Subject: RE: Please find attached amendment on planning application Ref: P/70/19/RES

APPLICATION NO: P/70/19/RES

Site Address: Land North of Summer Lane Pagham PO21 4NG

Description of Works: Approval of reserved matters following outline consent P/58/15/OUT for 90 No. dwellings.
Also seeking to address the terms of planning conditions 6 (Phasing), 8 (ecology), 9 (Surface Water), 12 (Vehicular Access), 15 (Parking), 18 (Travel Plan), 20 (Landscape Management), 24 (Parking Control), 25 (Dwelling Parking) and 26 (Materials)

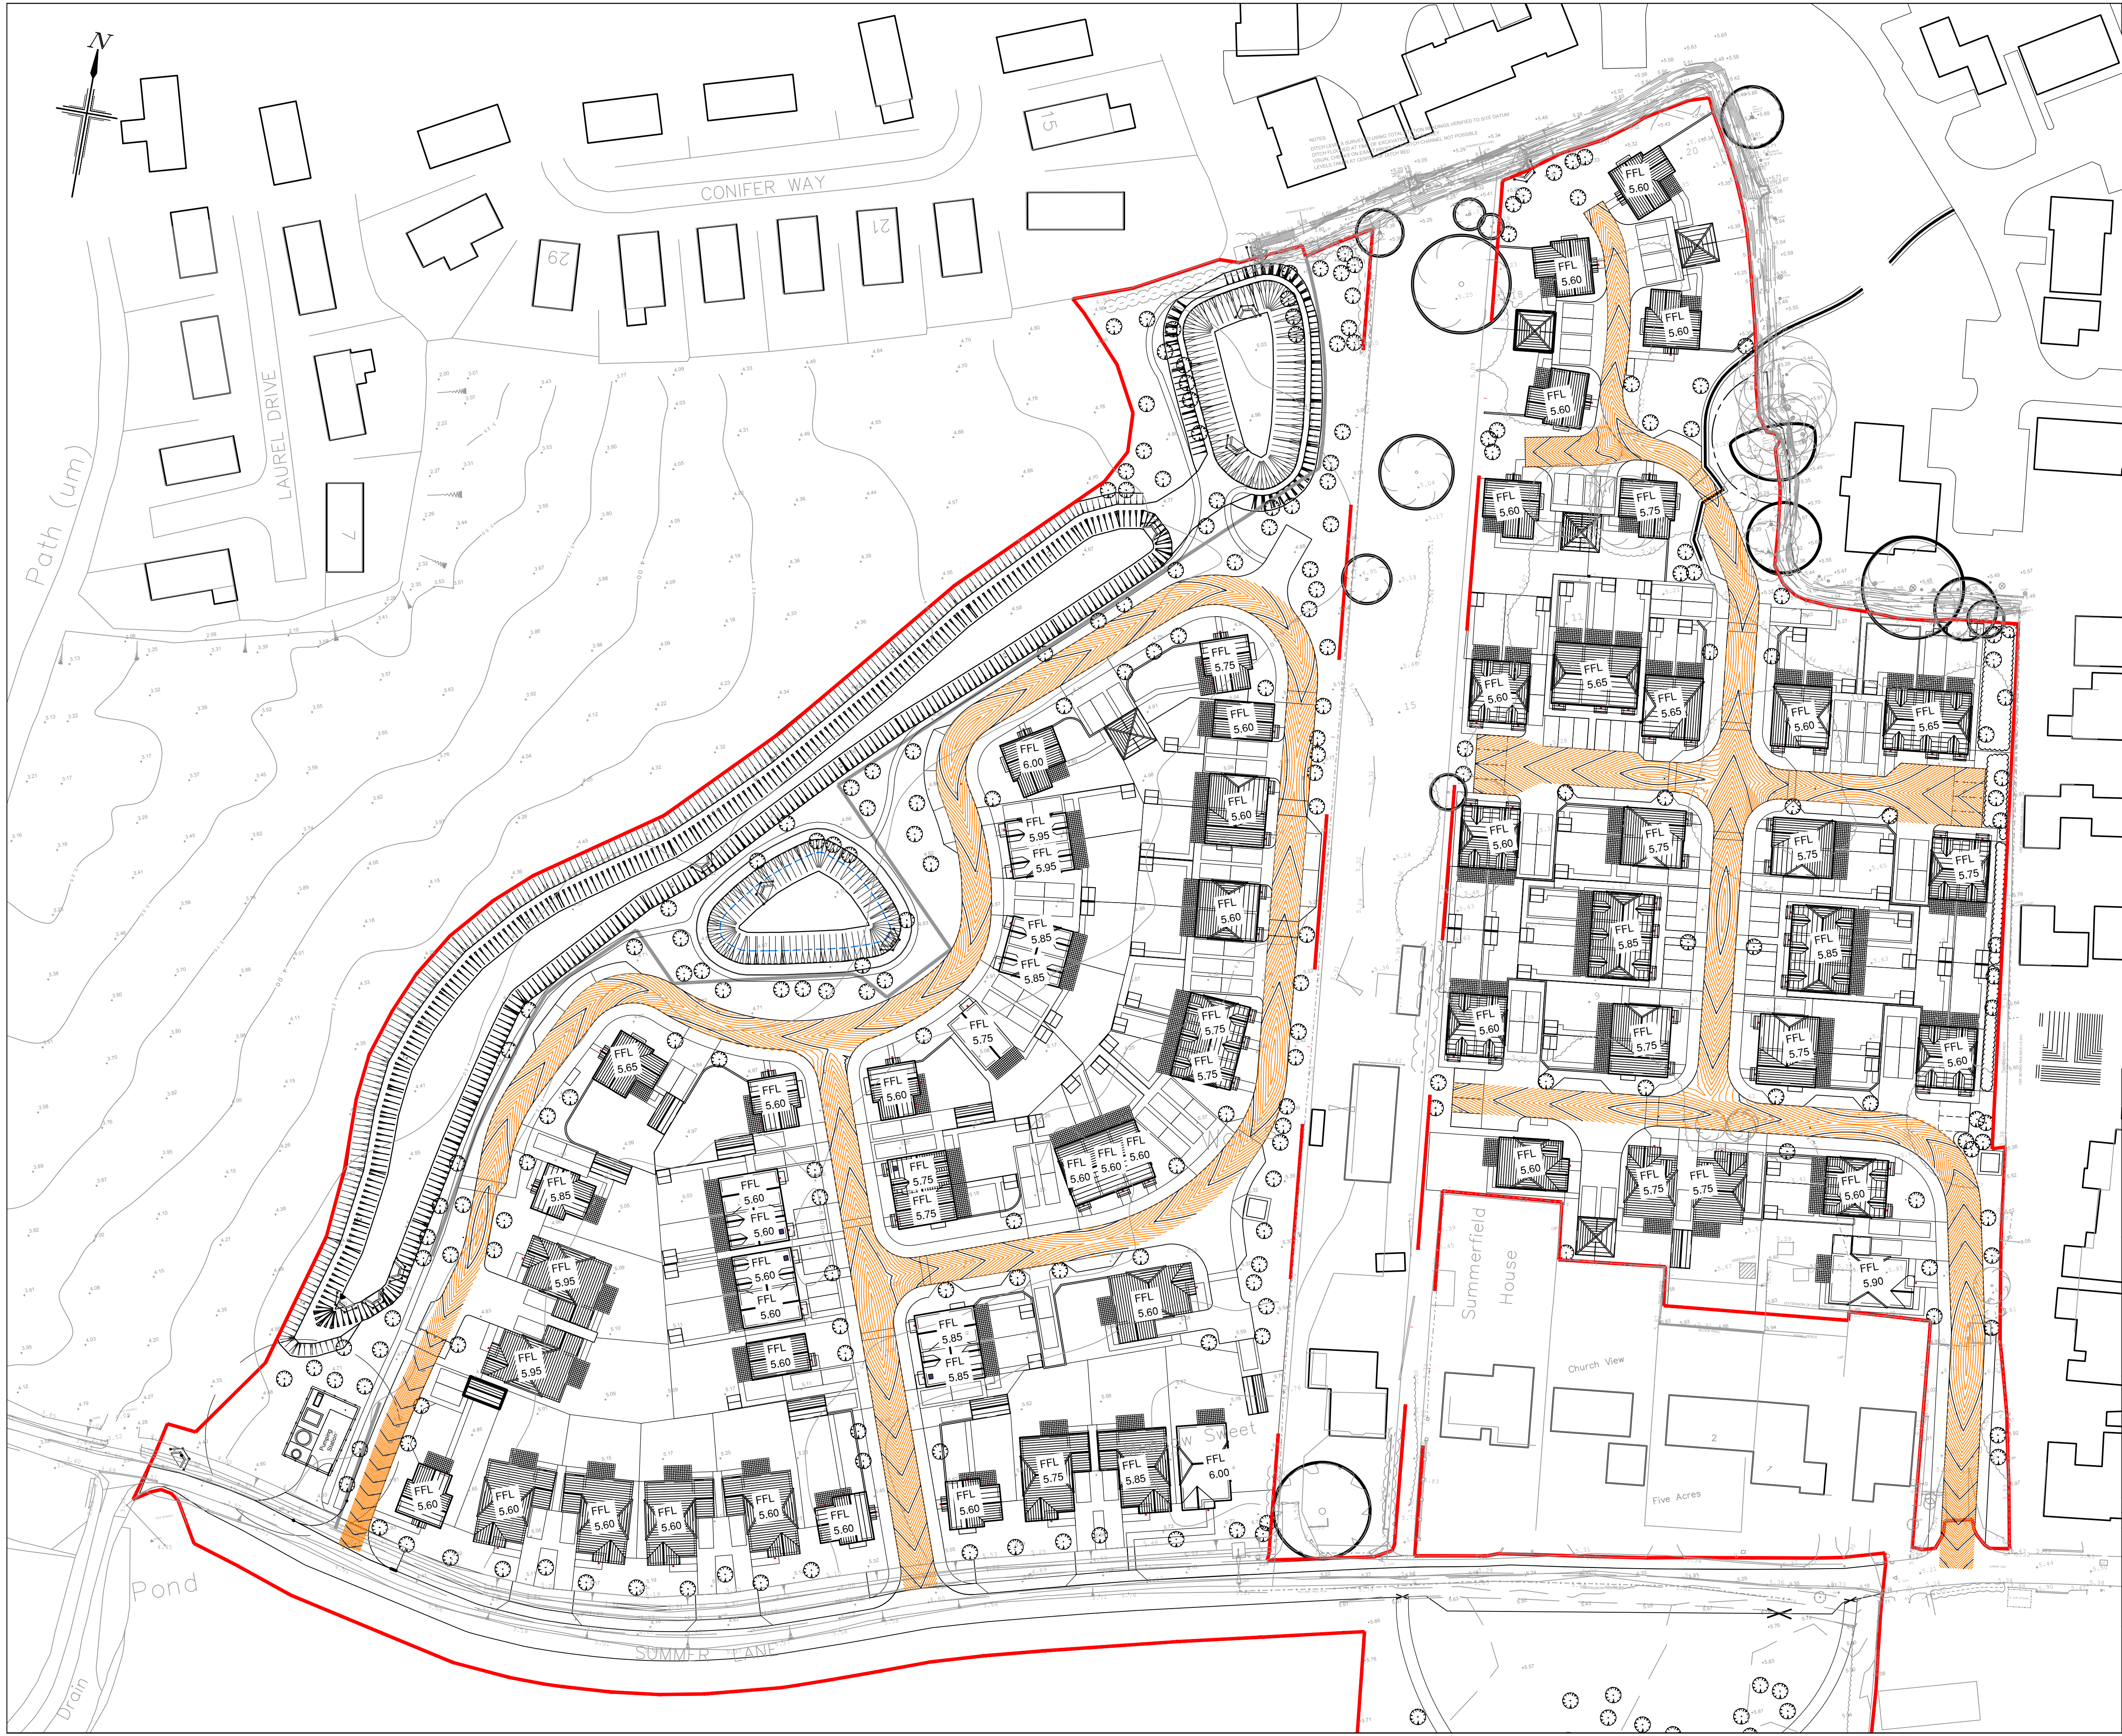
1. Drawing 1177 PD100 Rev P10, indicates 5 potential crossings over the ditch adjacent to Summer Lane. This is a reduction over previous proposals and is acceptable in principle. The crossings will need to take the form of culverts/pipes in order to avoid maintenance difficulties associated with bridges of such lengths/widths. The detailed design will be agreed via planning condition and Land Drainage consent.

2. The RCP report discusses the known erosion/undermining issues associated with previous excavations carried out in the northern boundary ditch. The ditch itself consists of unregistered land (owner unknown) whereby riparian responsibility lies with landowners either side, up to the centre of the ditch. As a result, Crayfern Homes need to be fully on board in terms of the proposals, since they are responsible for the northern half of the ditch. Whilst the report references the undermined surface water outfalls from the Crayfern development, it appears that no detailed discussions have been had with them in terms of finding a solution. It should be noted that the issues arose as a result of the contractors acting for the owners of the southern land parcel at that time and not as a result of Crayfern's actions. Whilst it is recognised that remedial works are required to correct the issues, it is recommended that dialog is commenced with Crayfern Homes as soon as possible so the principles can be established/agreed between all parties. The detailed design would be dealt with via Land Drainage consent as mentioned.

3. The Ardent report discusses capacities of the existing boundary ditches and the existing 300mm diameter culvert downstream of the proposed point of connection from the development site. There appears to be no mention in the report of taking account of groundwater in the capacity calculations which could have a significant impact. Please note that Ditch B is also likely to receive flows from roofs/hardstanding's, etc associated with existing properties alongside Summer Lane, as we know of some of these connections existence, and possibly from Sylvia Close too, since are aware of a possible culvert exiting Sylvia Close and

connecting to the Summer Lane culvert. This will need to be investigated as it may encroach into the development site's SE corner and if this is the case further discussion will need to be had. It should also be noted that a disused weir exists some 140 metres downstream of the 300mm diameter culvert which hasn't been mentioned in the report and may impact flows.

In terms of the proposal to redirect the northern ditch into the onsite suds system, and the fact that groundwater (which cannot be quantified) will enter the system via the northern ditch, is not a proposal that we would entertain, due to the unknown groundwater effects on capacity, operation of the suds, etc. A more satisfactory option would be to;

1. Keep the northern ditch independent of the onsite suds and work together to further investigate the existing culvert downstream (ie. on southern boundary of Mill Farm Park Estate) to ensure the free flow of water in a westerly direction.

2. Connect the surface water drainage from the eastern portion of the development into the western portion, rather than connecting the eastern portion directly into the northern ditch. Of course this will mean laying a pipe across third party land, but this can be achieved by either negotiation with the landowner or by approaching Southern Water to use their statutory powers to requisition a pipe across the land in question.

3. The 300mm pipe downstream of the developments discharge will need upsizing based upon the unknown groundwater influence in terms of capacity and to also reduce blockage risk.

4. The disused weir should be investigated and removed if found to be detrimental/not required.
